# FOREST LAKES FILING NO. 6

A REPLAT OF TRACT B AS PLATTED IN FOREST LAKES FILING NO. 5 RECORDED UNDER RECEPTION NO. 220714540 RECORDS OF EL PASO COUNTY, COLORADO TOGETHER WITH A PORTION OF THE SOUTHWEST QUARTER OF SECTION 28 AND THE SOUTHEAST QUARTER OF SECTION 29, ALL IN TOWNSHIP 11 SOUTH, RANGE 67 WEST OF THE SIXTH PRINCIPAL MERIDIAN, EL PASO COUNTY, COLORADO

# Plat V\_1 redlines.pdf Markup Summary 11-25-2020

FOREST LAKES FILING NO. 6 JOB NO. 1175.60 AUGUST 14, 2020 SHEET 1 OF 6

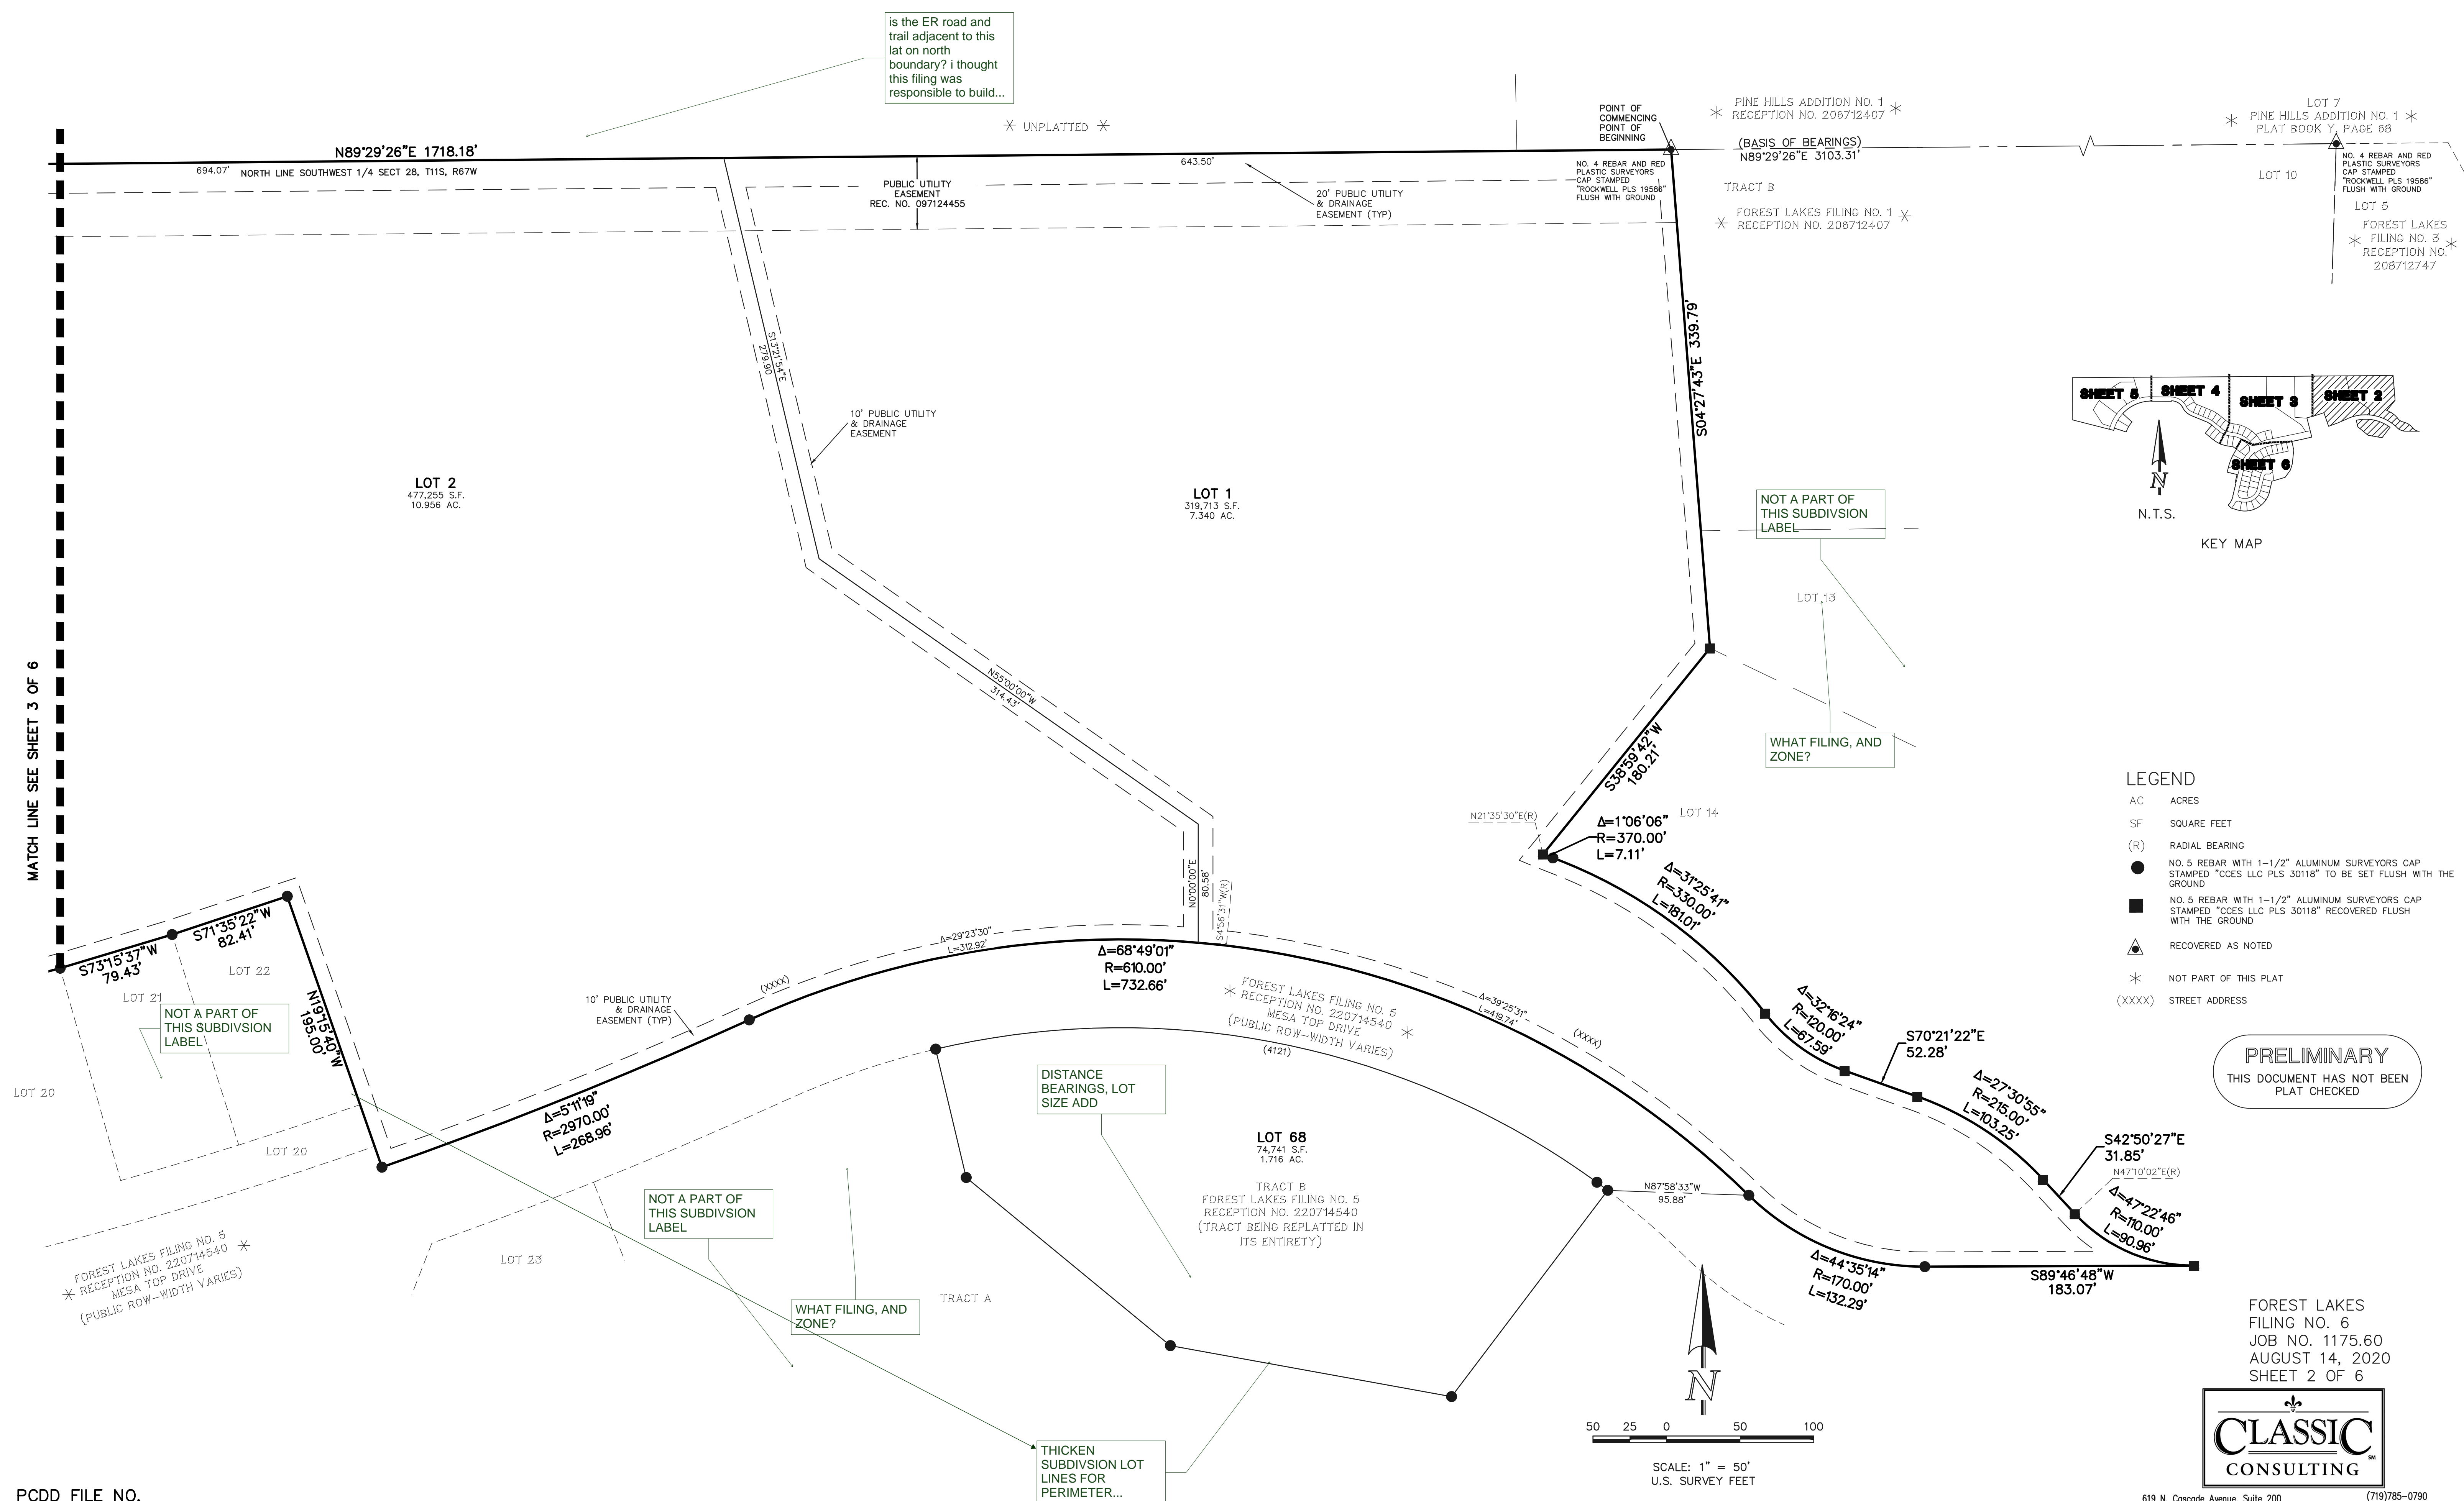
is the ER road and trail adjacent to this lat on north  
boundary? i thought this filing was responsible to  
build...

NOT A PART OF THIS SUBDIVISION LABEL

WHAT FILING, AND ZONE?

DISTANCE BEARINGS, LOT SIZE ADD

THICKEN SUBDIVISION LOT LINES FOR PERIMETER...

FOREST LAKES FILING NO. 6  
 JOB NO. 1175.60  
 AUGUST 14, 2020  
 SHEET 3 OF 6

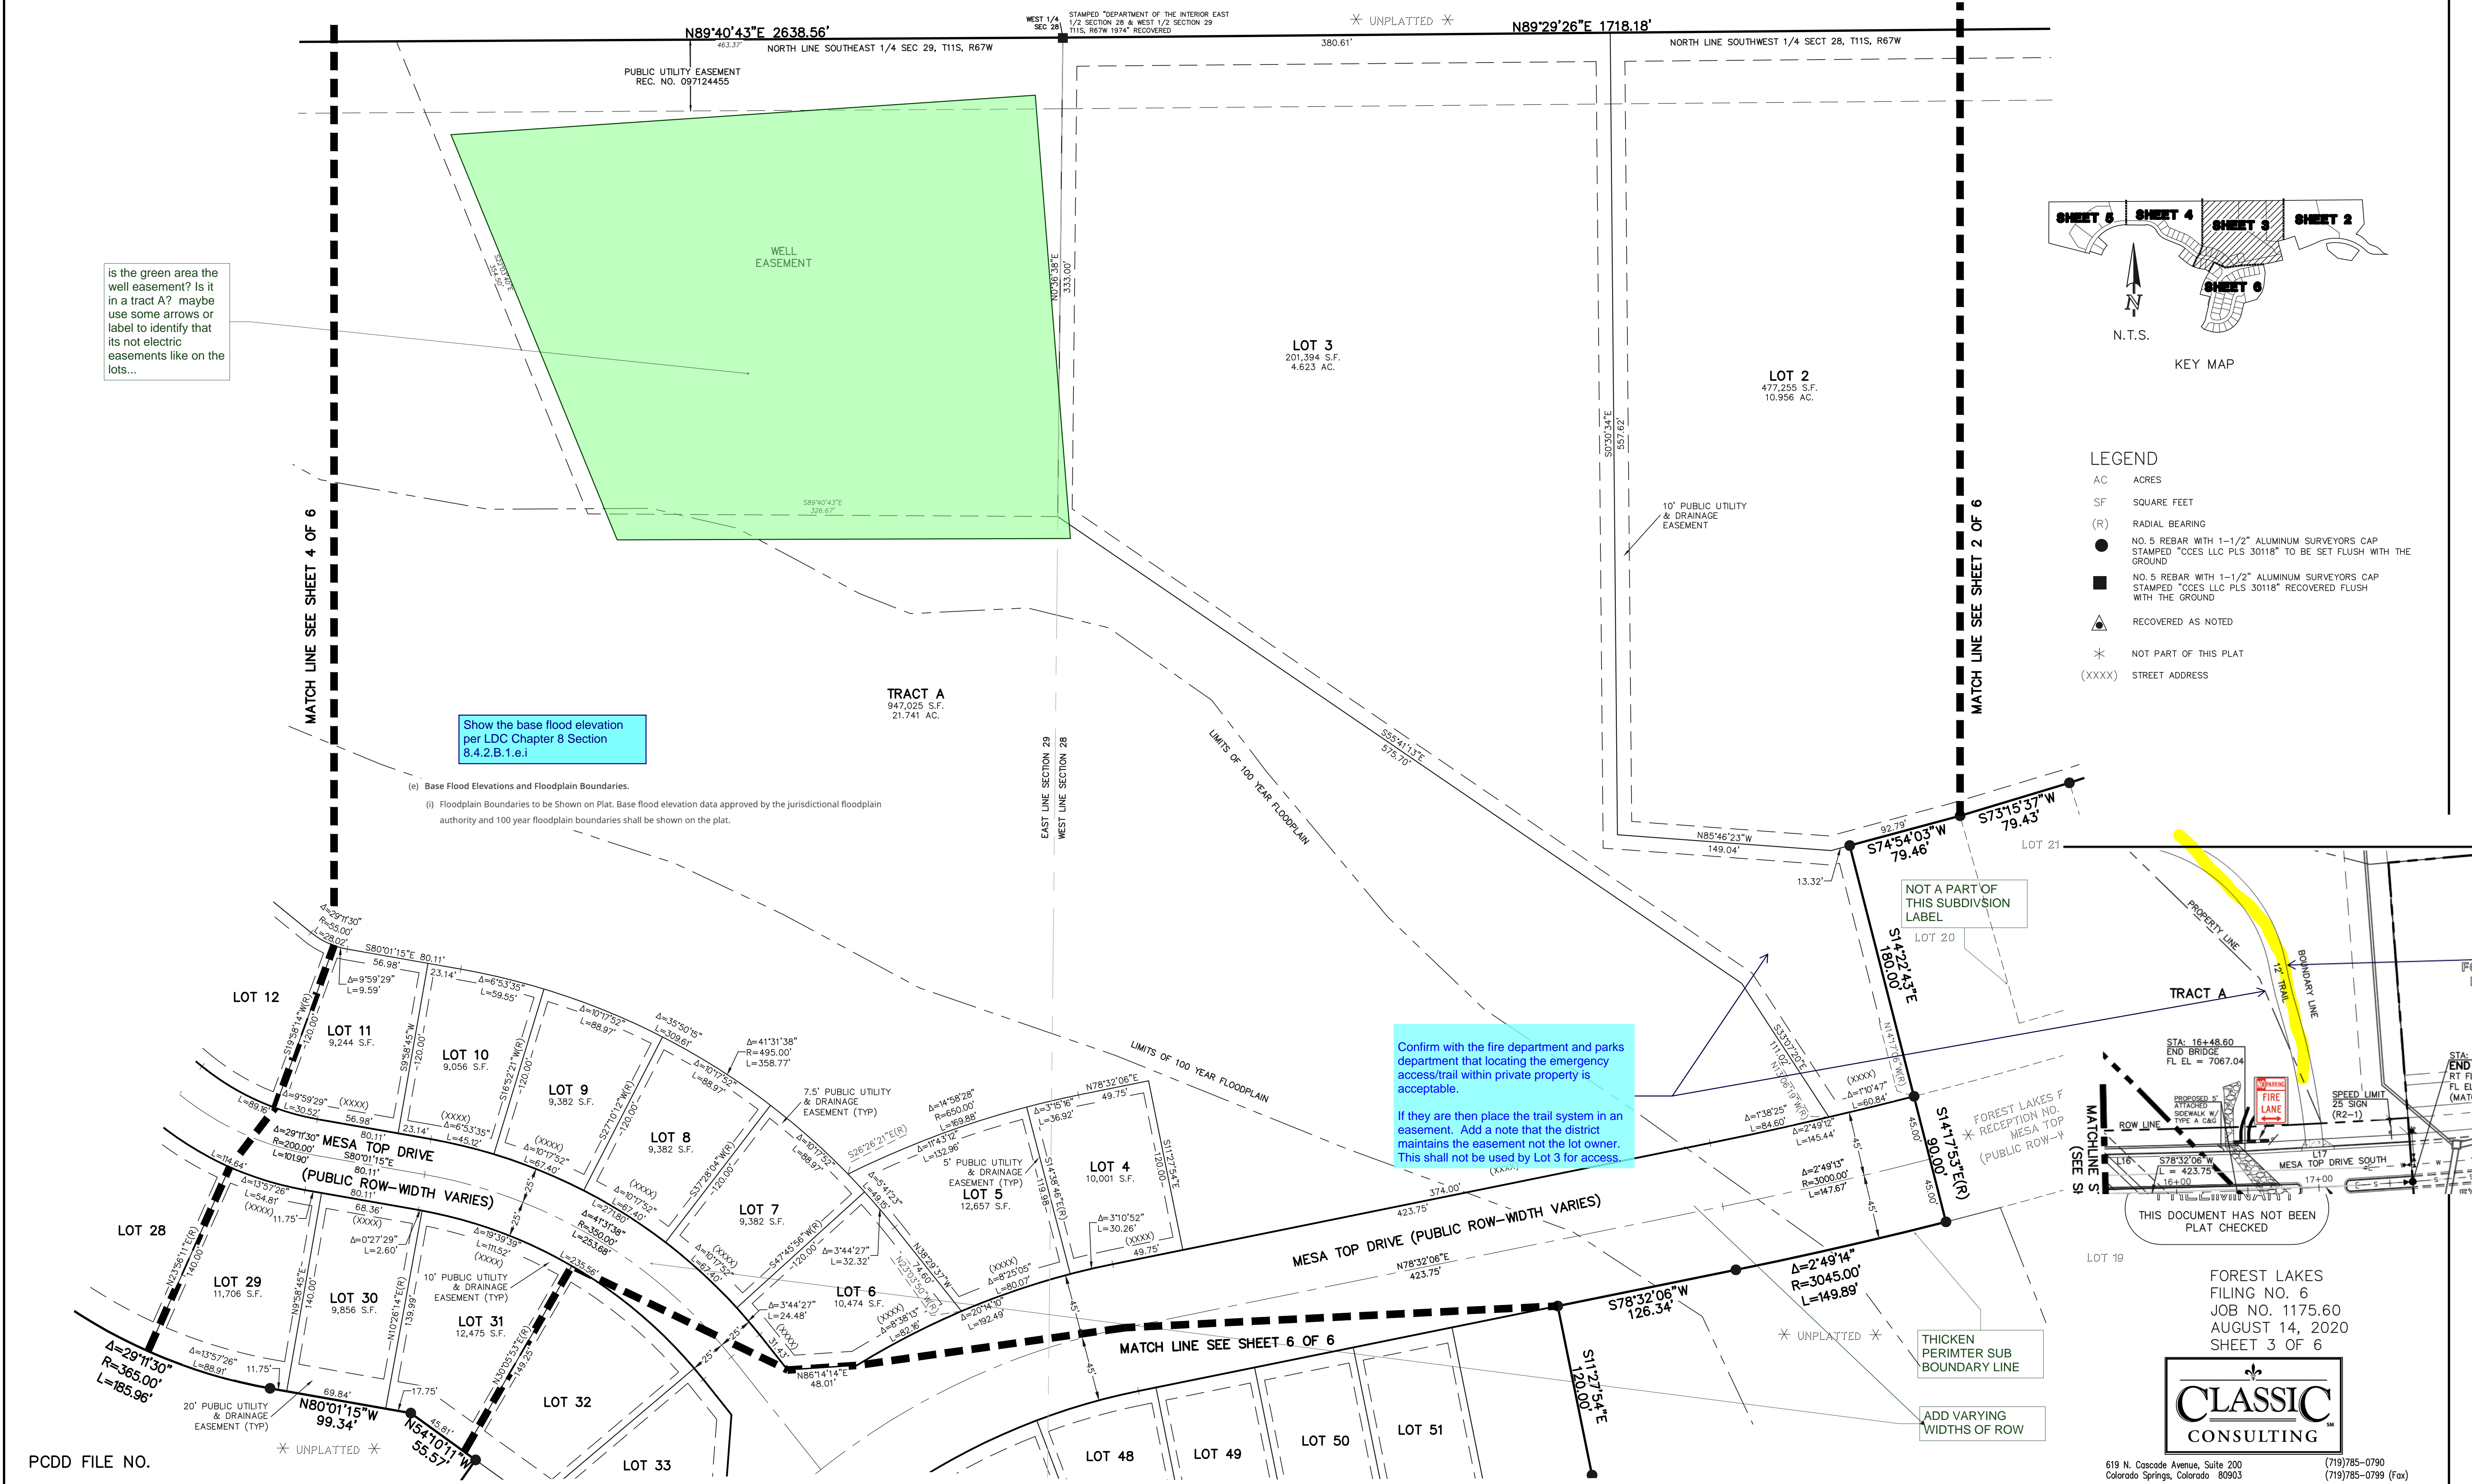
is the green area the well easement? Is it in a tract  
A? maybe use some arrows or label to identify  
that its not electric easements like on the lots...

ADD VARYING WIDTHS OF ROW

THICKEN PERIMTER SUB BOUNDARY LINE

FOREST LAKES FILING NO. 6  
JOB NO. 1175.60  
AUGUST 14, 2020  
SHEET 4 OF 6

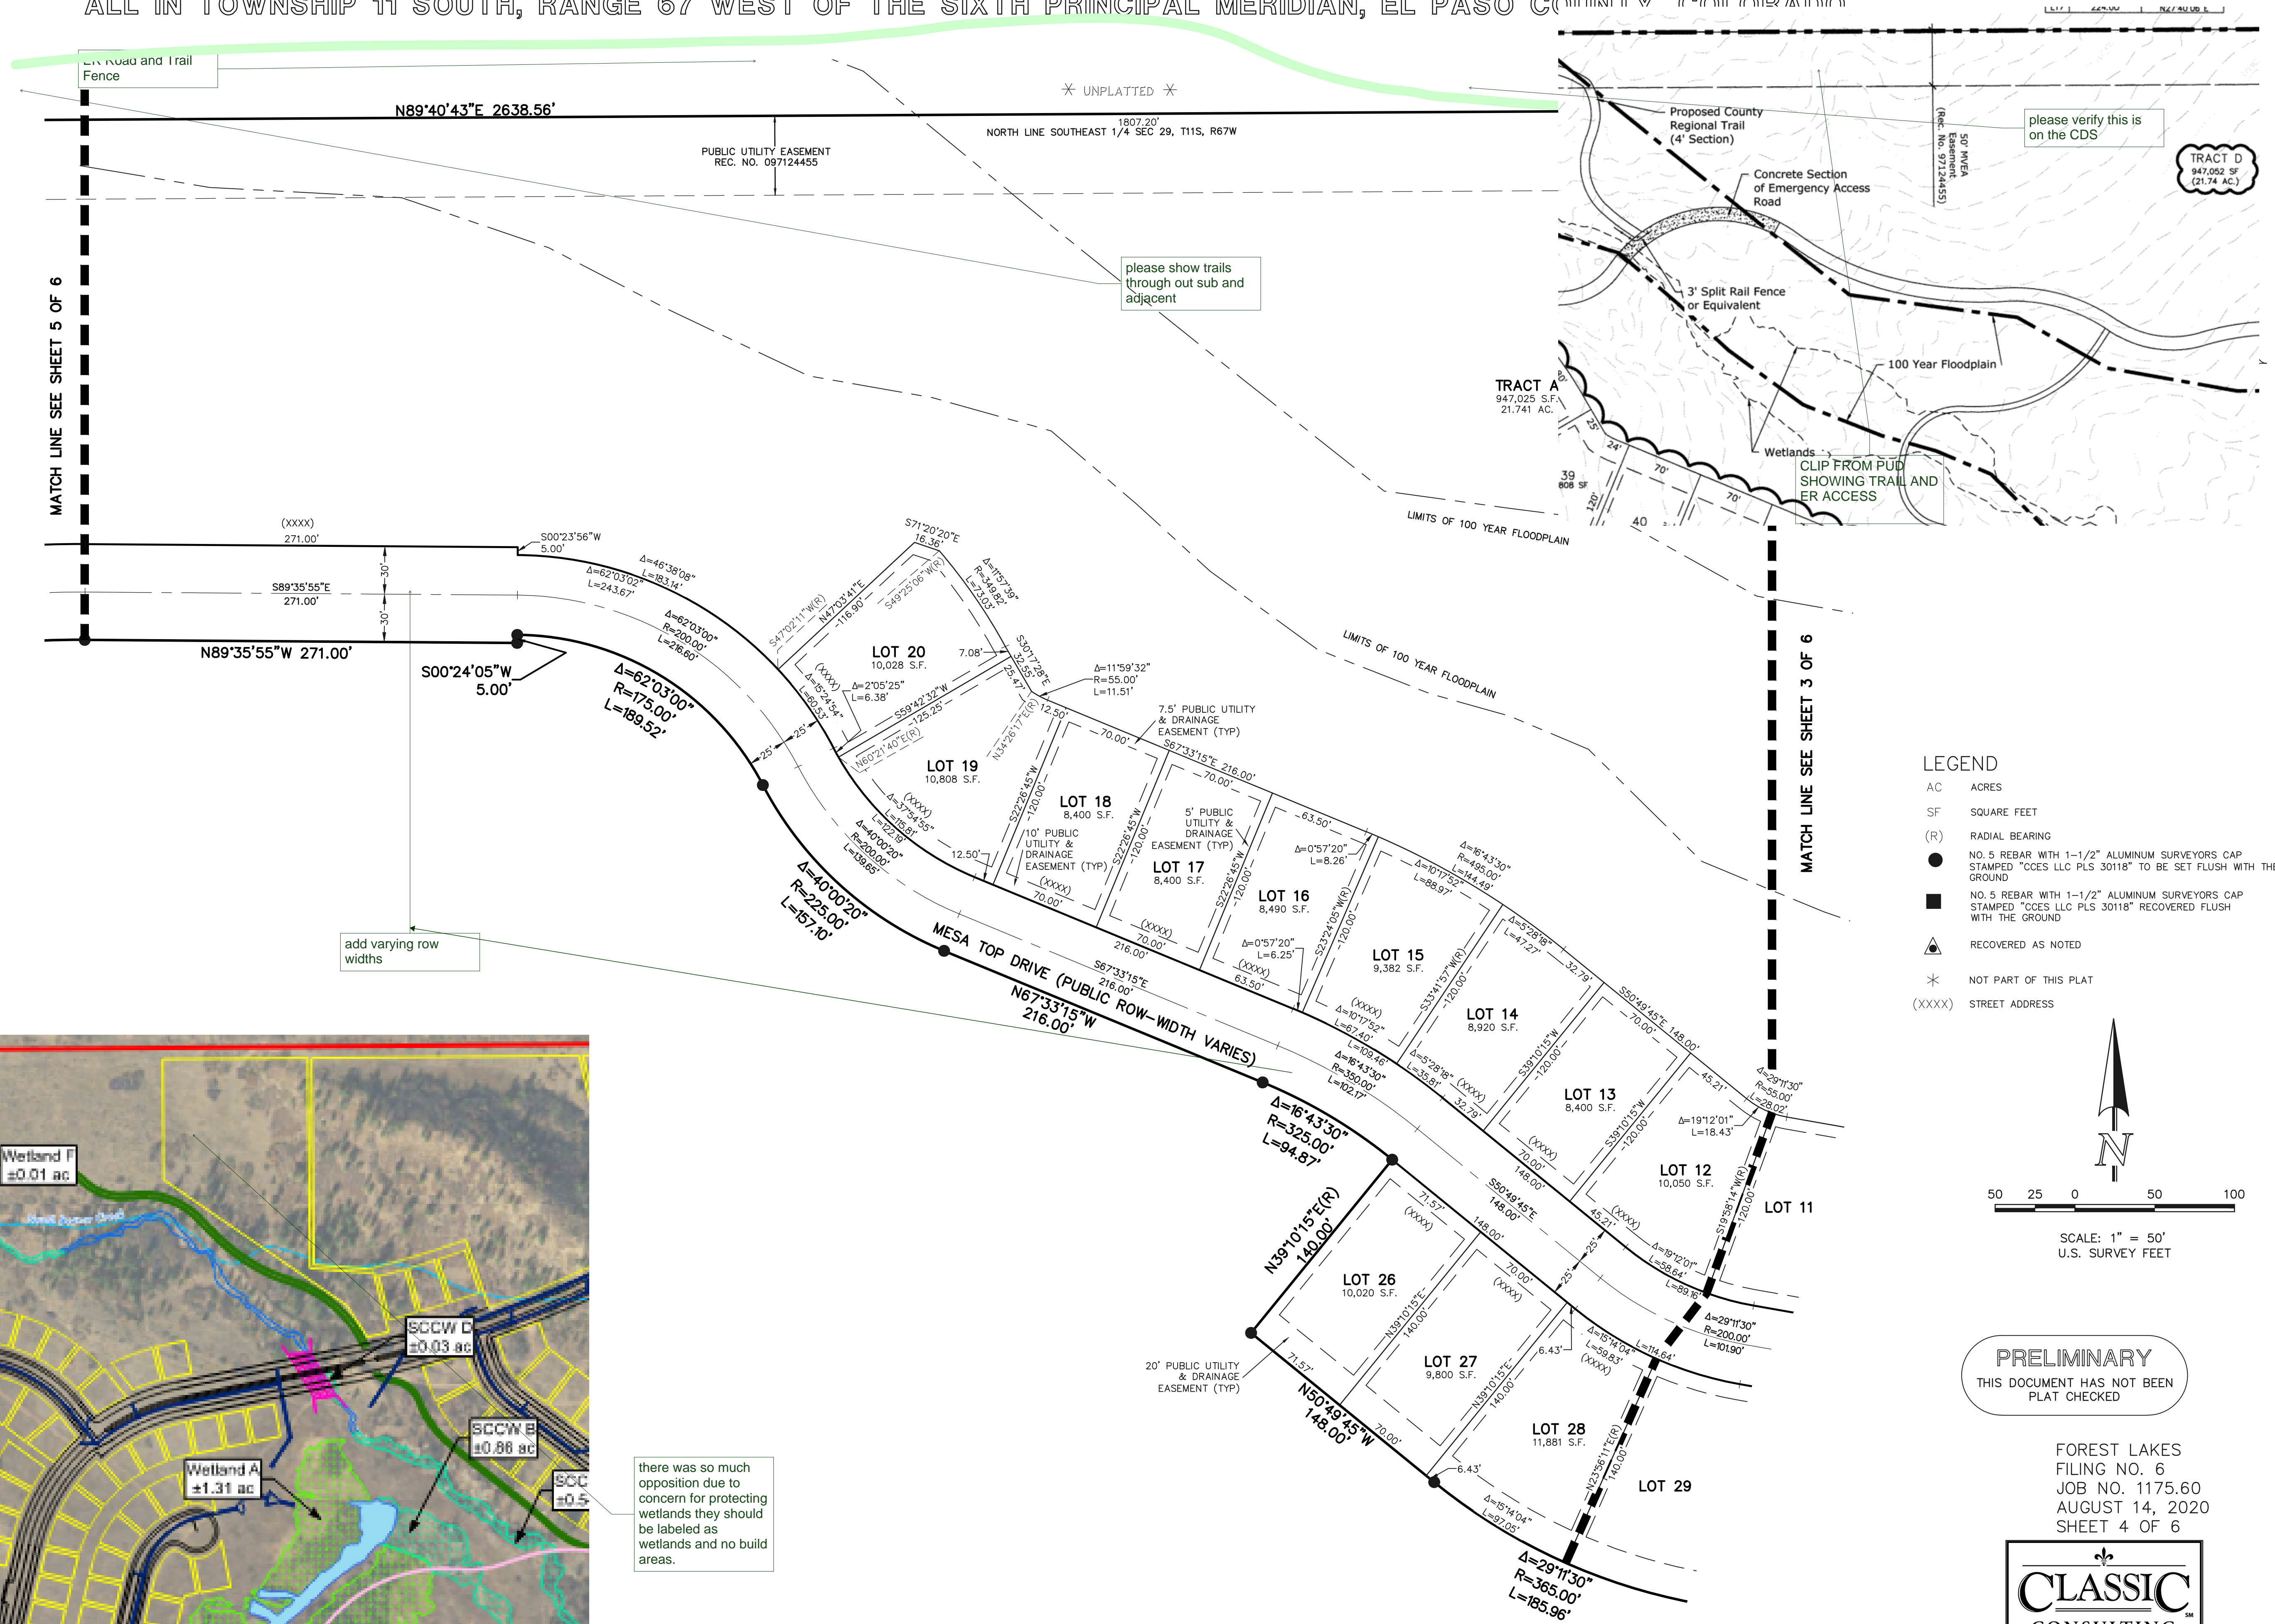
is this the water tank site; there should be a looping trail through here...

add varying row widths

there was so much opposition due to concern for protecting wetlands they should be labeled as wetlands and no build areas.

please show trails through out sub and adjacent

please verify this is on the CDS
